CITY OF ALBUQUERQUE

**Re: Albuquerque Vault, 300 Airport Drive NW, Grading and Drainage Plan
Engineer's Stamp dated 6-22-05 (K10-D8)**

Based upon the information provided in your submittal received 6-22-05, the above referenced plan cannot be approved for Building Permit until the following comments are addressed:

# GRADING PLAN

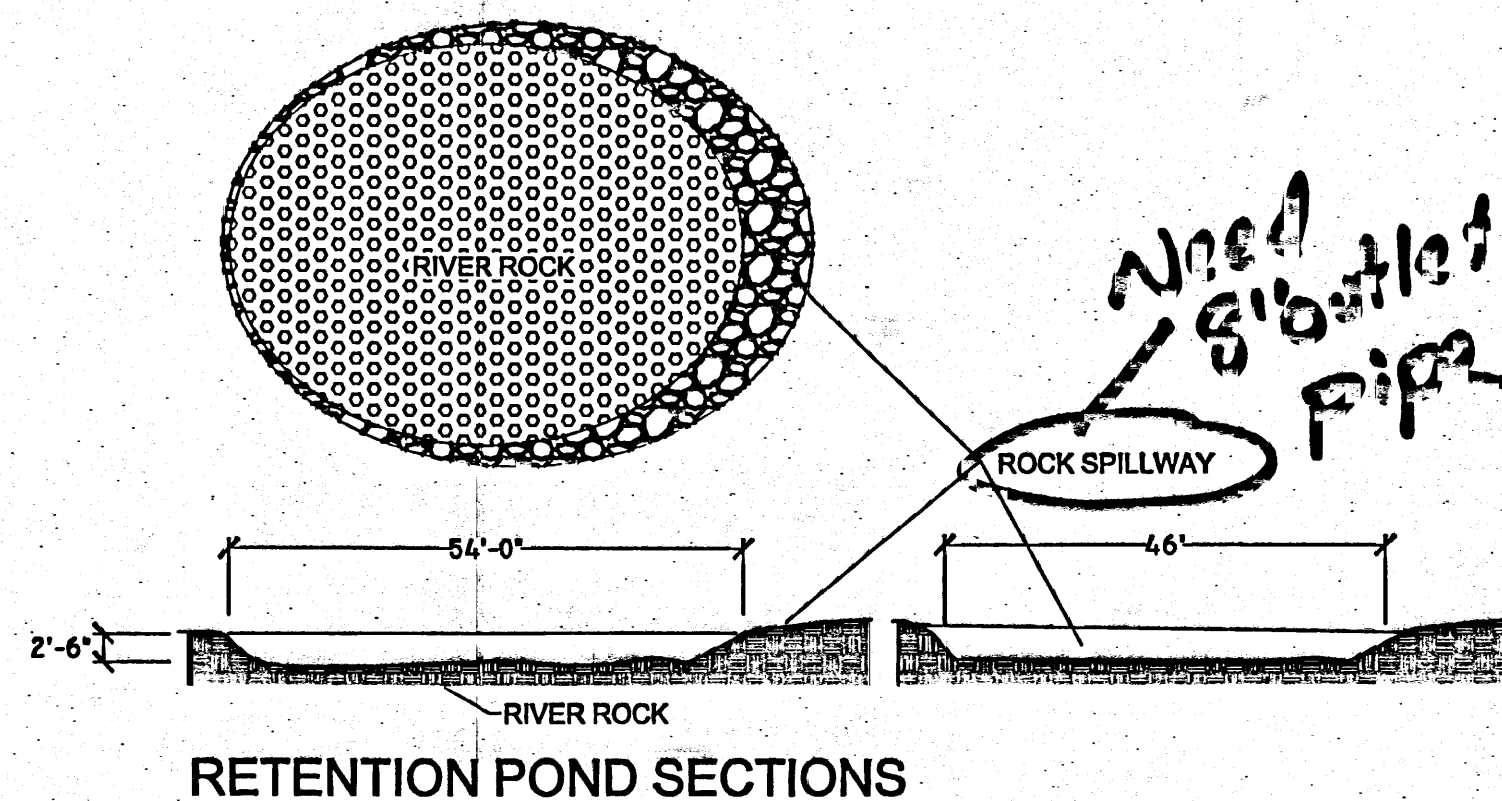
1. Show the existing storm drain located in Airport Drive. Is there an existing tie-in at this site?
2. The calculations refer to "state owned property." I am unaware of any state owned property located within this site.

5. All flow for the site should be guided to the detention pond, as shown on the typical site layout.
6. As clearly defined in the Development Process Manual, Chapter 22, Section 8, the following data must be provided for all proposed ponds:

8. The proposed detention pond will tie in to the existing storm drain system. You must design this connection and provide details.
9. The typical sections provided on the grading and drainage plan are not used in this plan. If these details are not to be used, remove them.
10. Please update the executive summary shown on the grading and drainage plan. It continues to refer to areas and information from the Blue Hole Limited Lot 15B project. The executive summary must refer to this project only.
11. A benchmark must be referenced on this plan.

## RETENTION POND SECTIONS

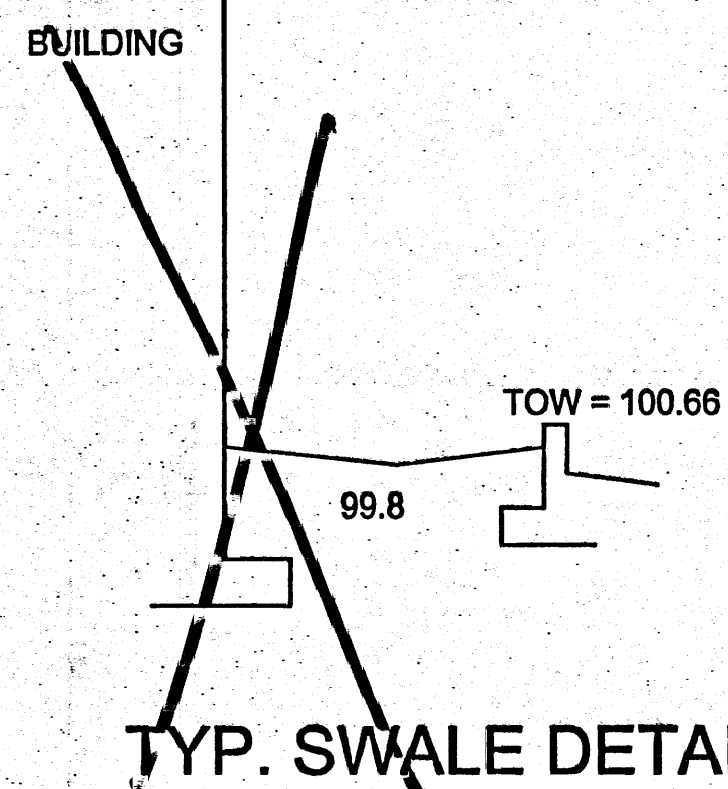
3. The above referenced project is located within the Atrisco Business Park Master Plan. As specified in this plan, the maximum 100-year storm water discharge is 0.1 cfs per acre. A typical 2.5-acre lot is shown in this plan. Redesign this project to be in compliance with the Master Plan.

4. Please note that you will be designing a detention pond, not a retention pond. Flow is restricted at the inlet to 0.23 cfs (0.1 cfs per acre), but flow will be exiting the pond. Therefore, you are detaining the flow, but not retaining it permanently.
